Your Ref:
Our Ref: TR010018
Date: 27 January 2015

Application by the Highways Agency for an Order Granting Development Consent for the A14 Cambridge to Huntingdon Improvement Scheme

Advice following issue of acceptance decision

**BUCKDEN ROAD NORTH WORK NO. 9 - WORKS PLANS SHEET NO. 7 (GENERAL ARRANGEMENT SHEET NO. 5 & 6)**

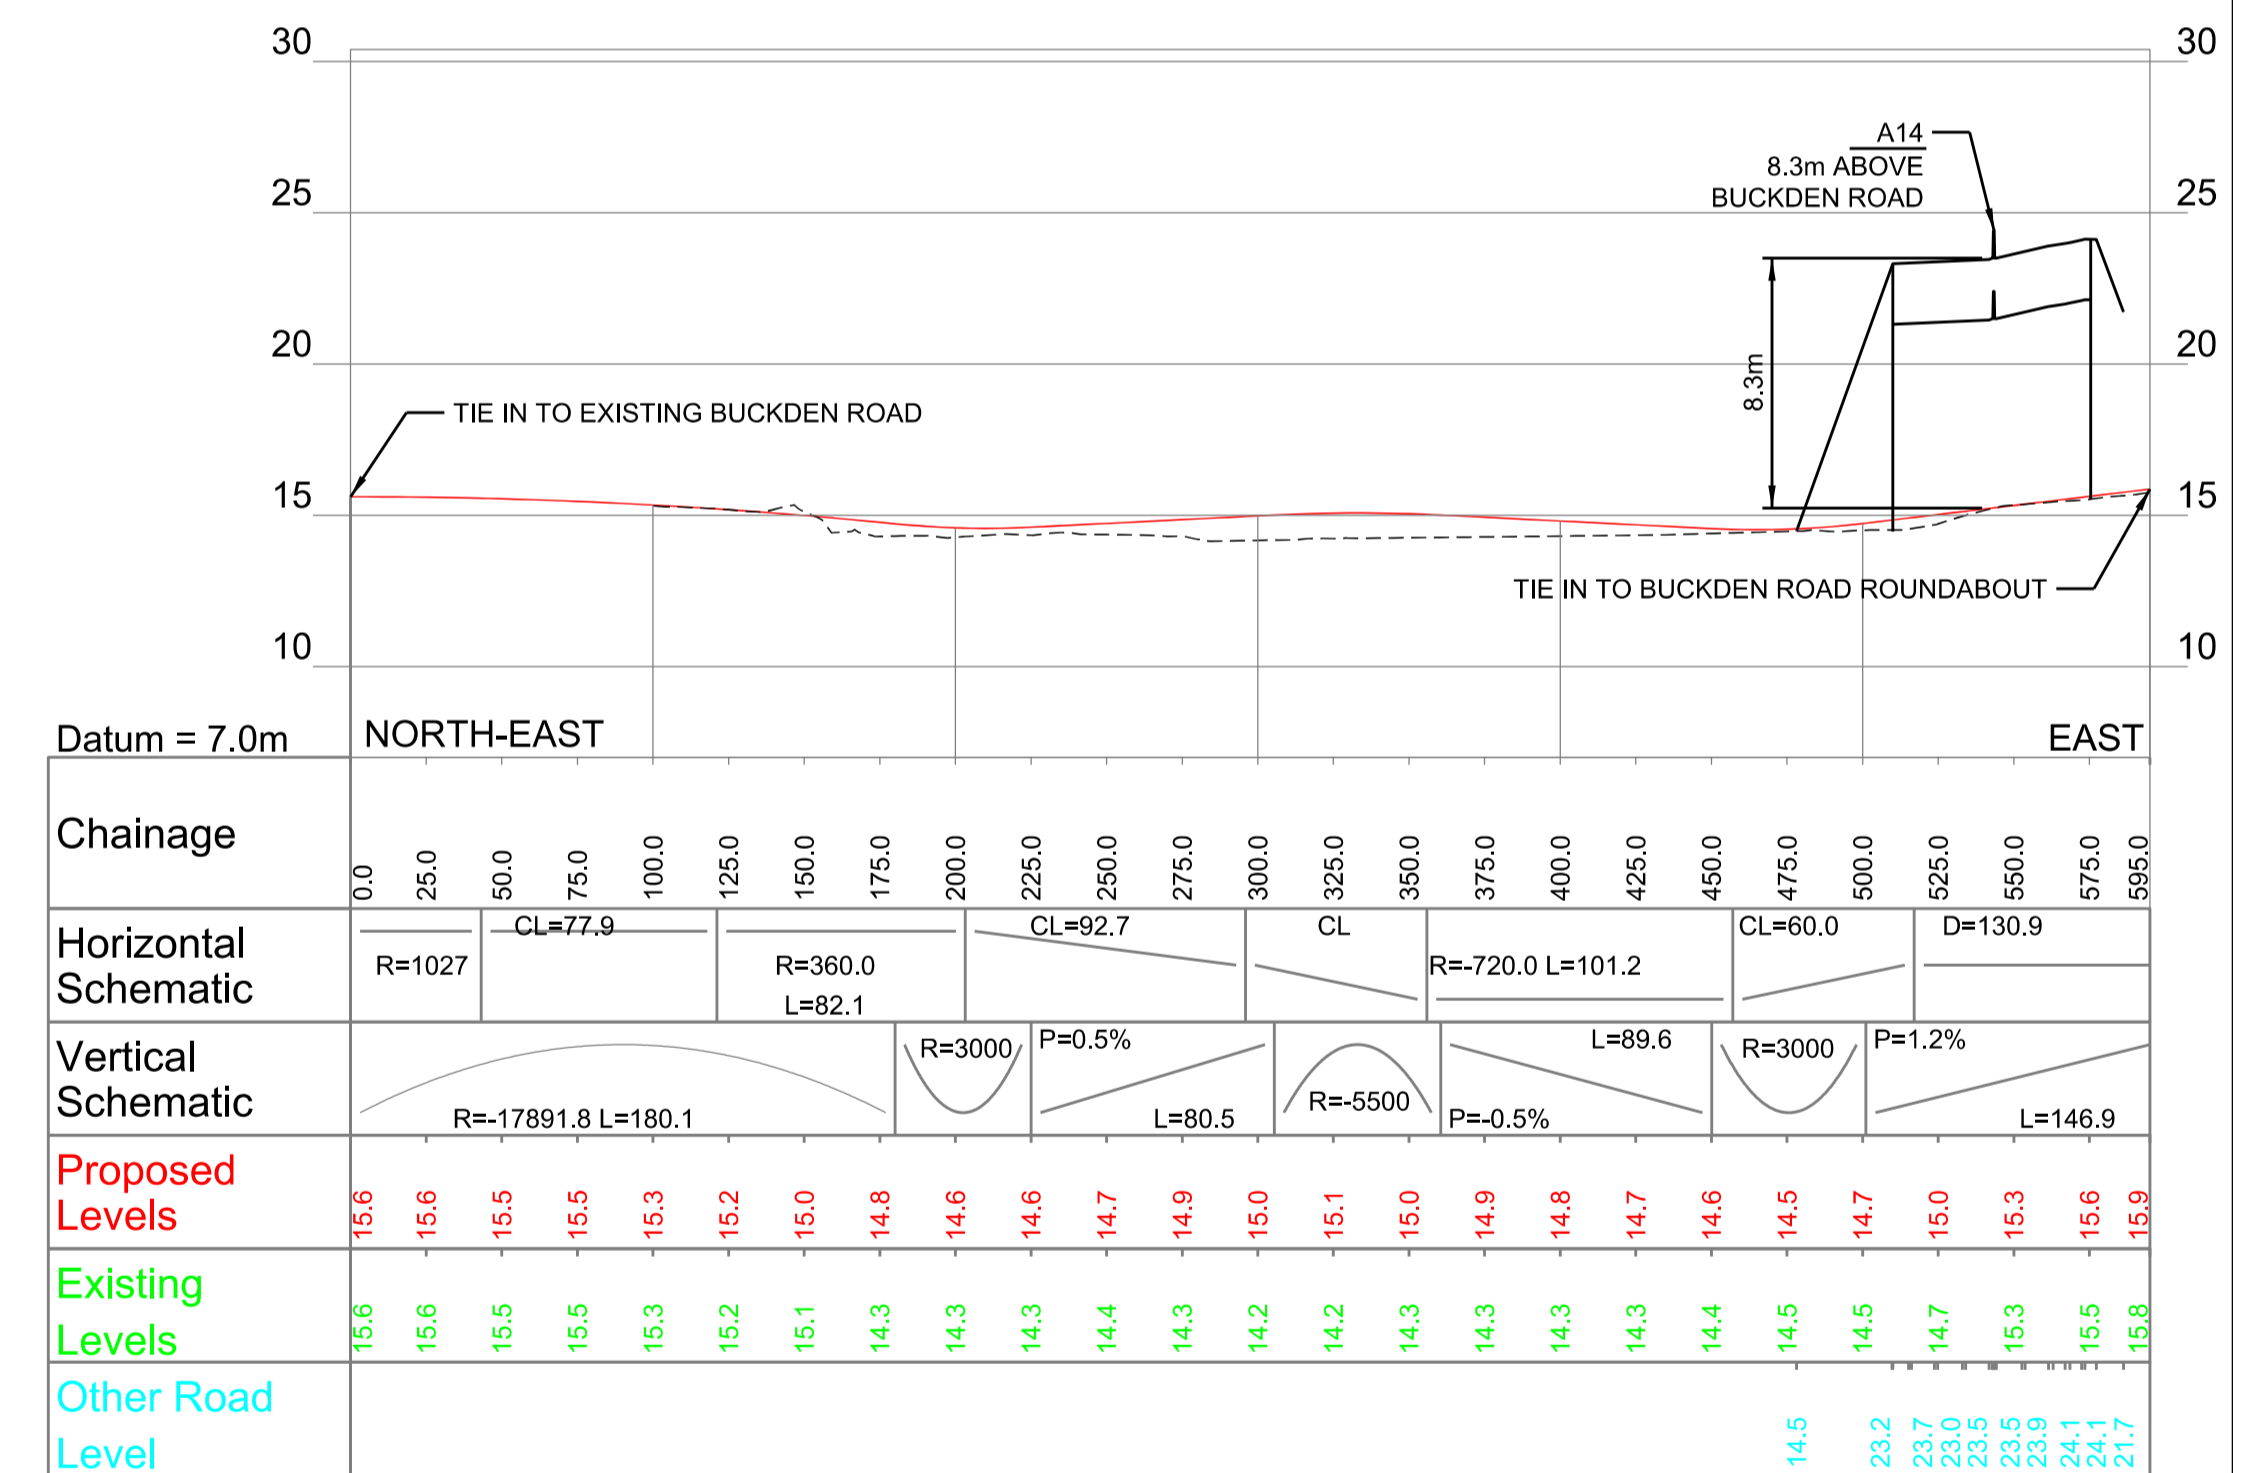
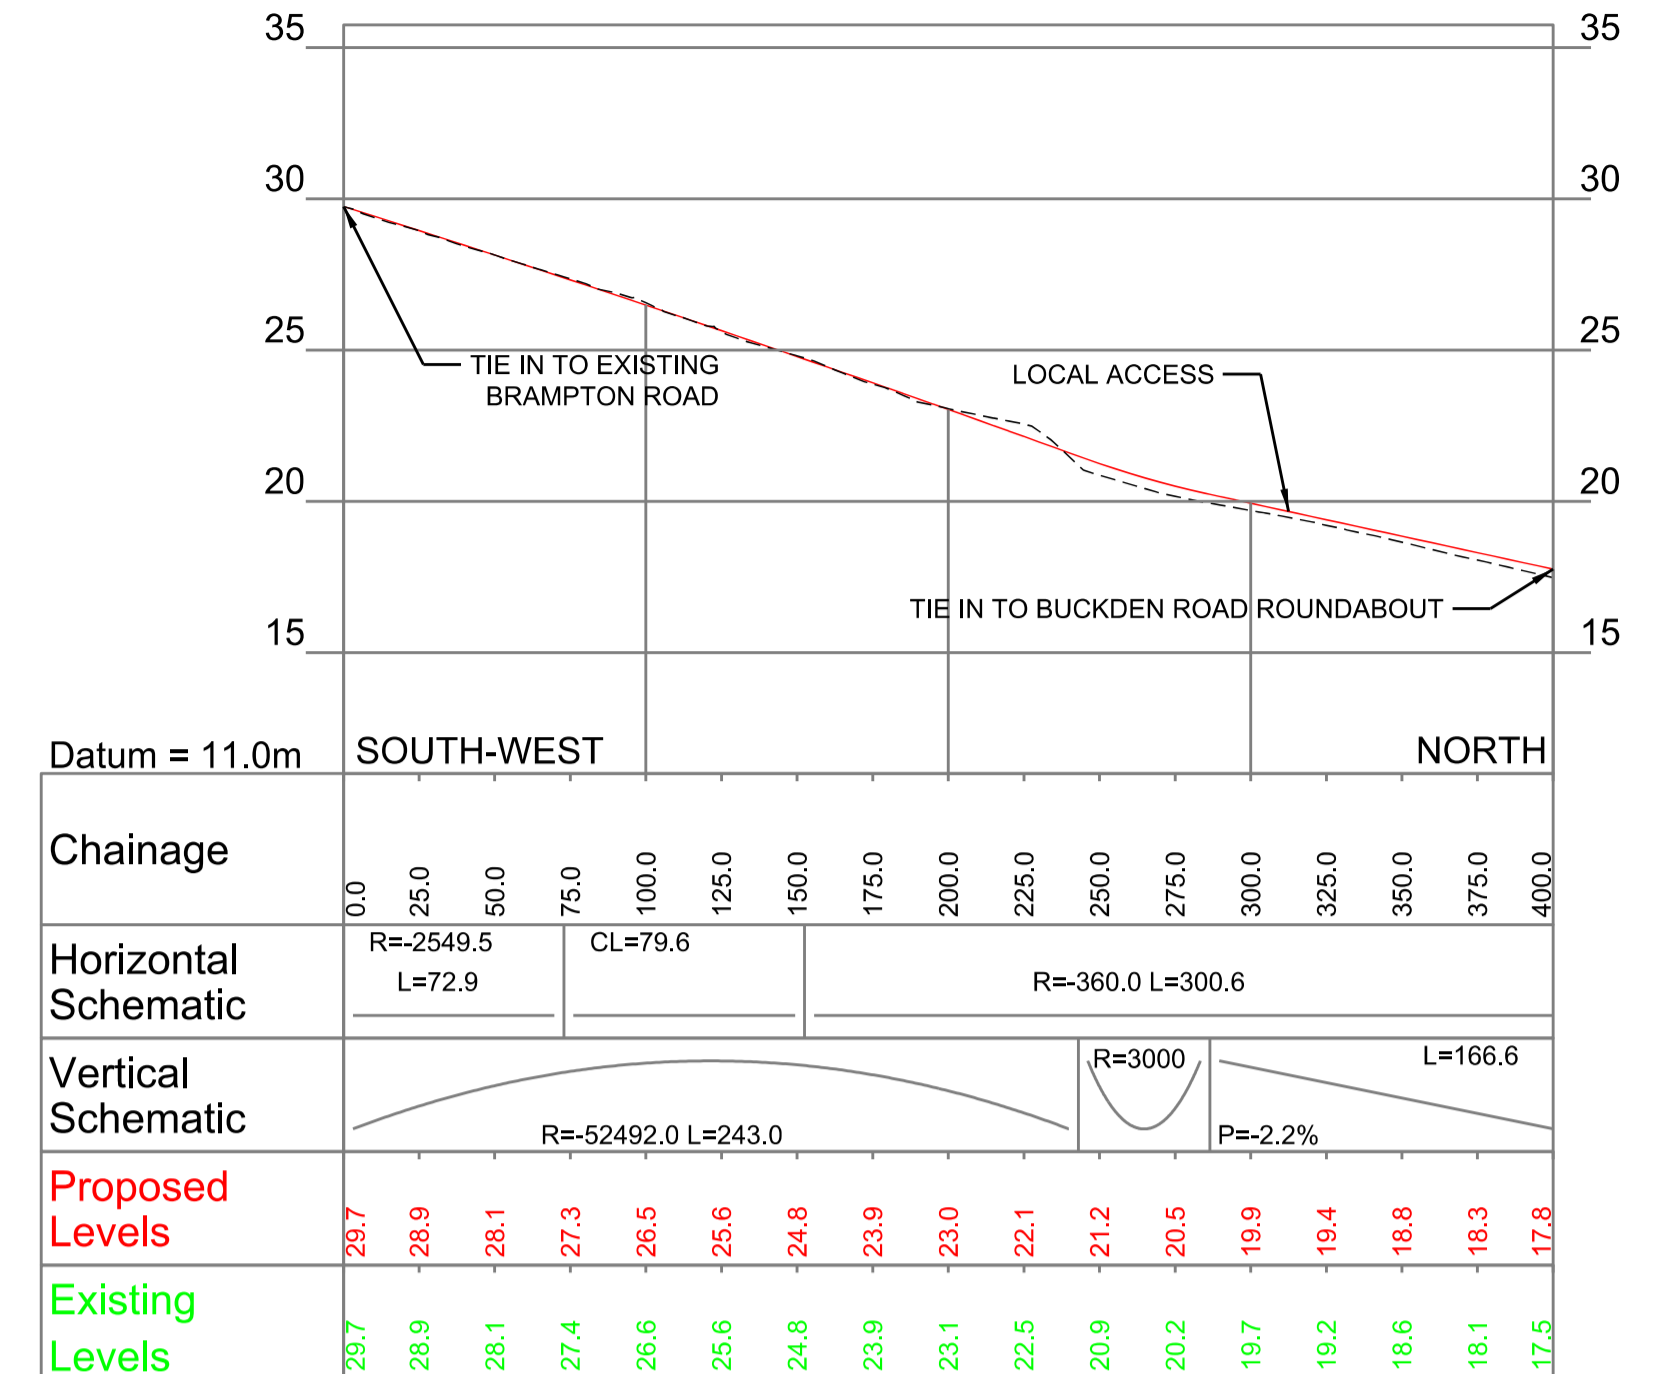
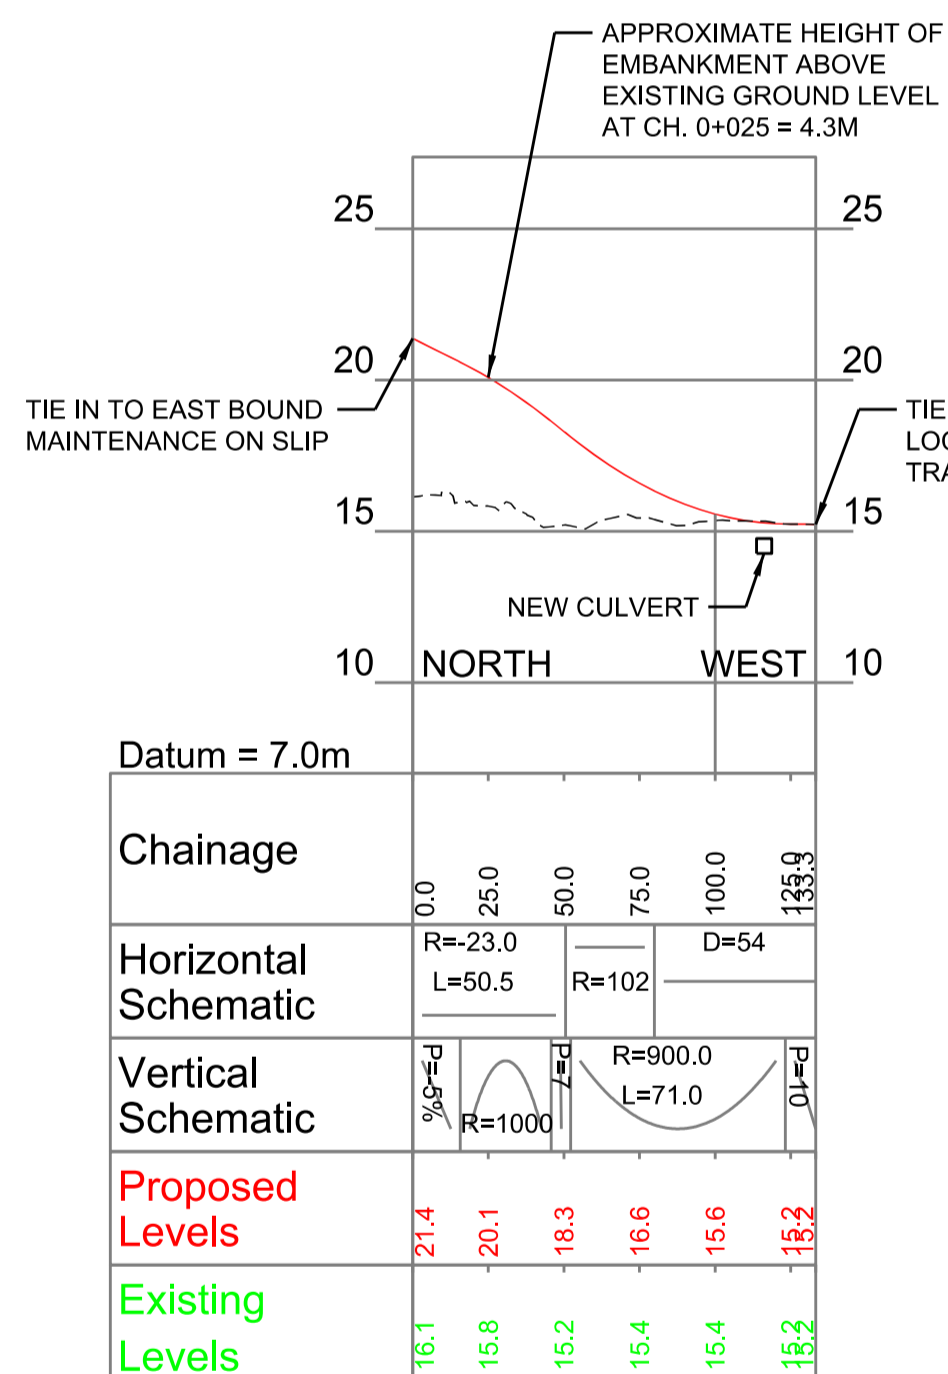
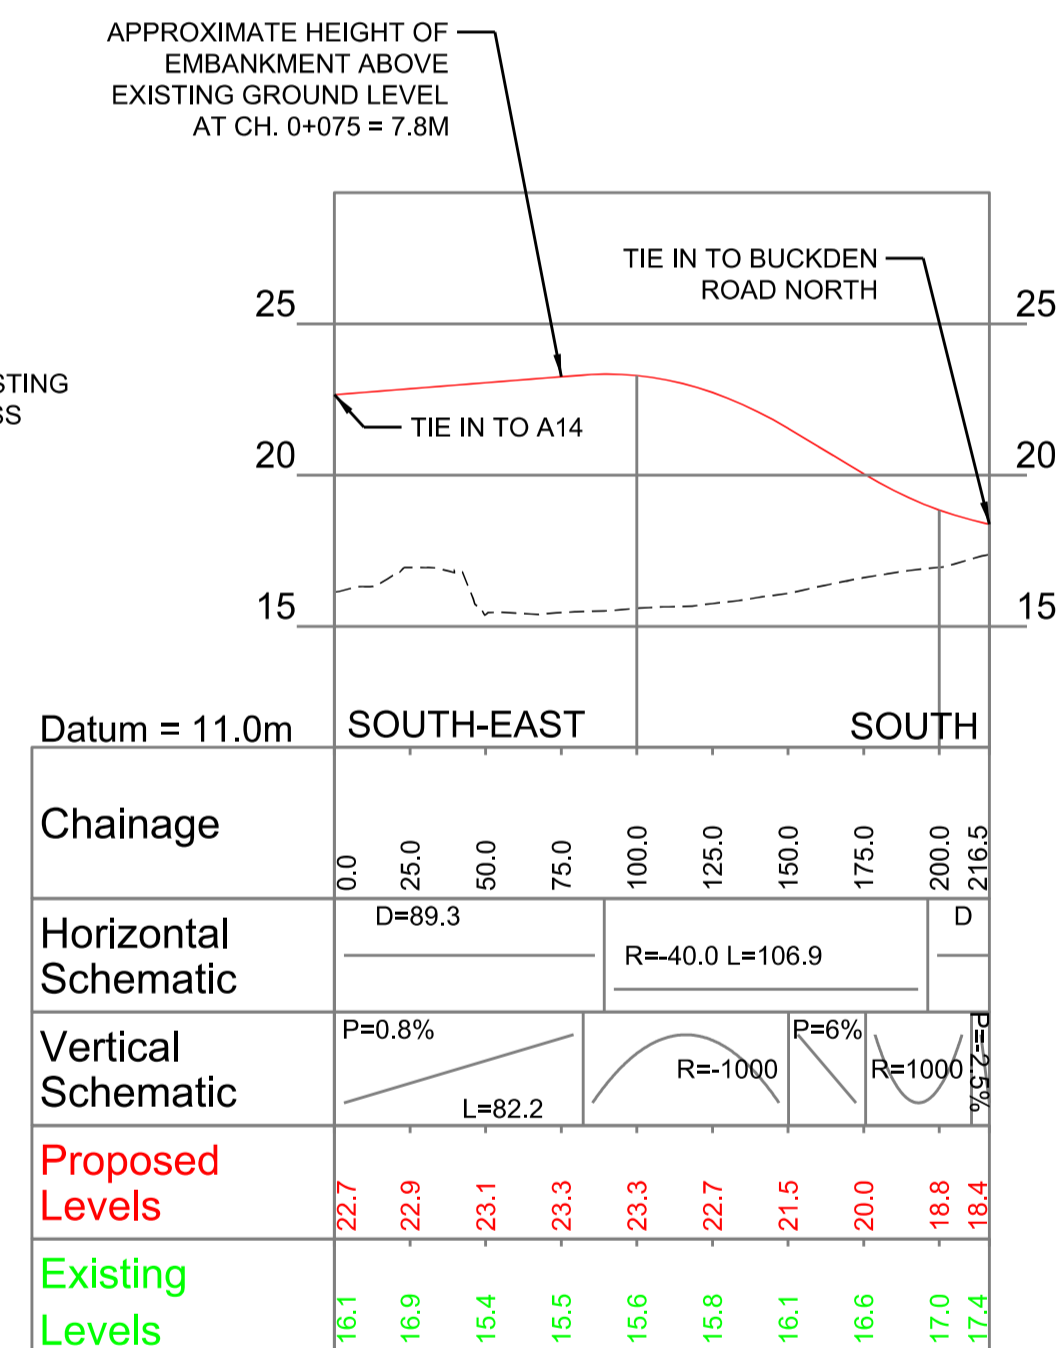
The Section Drawings can be difficult to follow as they do not appear to proceed in a logical order. Referencing the sections to Works Plans is also problematic, as frequently the features shown in section do not appear on the Works Plans.

A number of labelling errors have been listed in the s55 checklist which should be corrected. Where a number of similar works exist in proximity, such as in Huntingdon Town Centre, a map could be provided to identify them. The Inspectorate also considers that the ends of each section line could be labelled East/West etc as the aspect is not consistent.
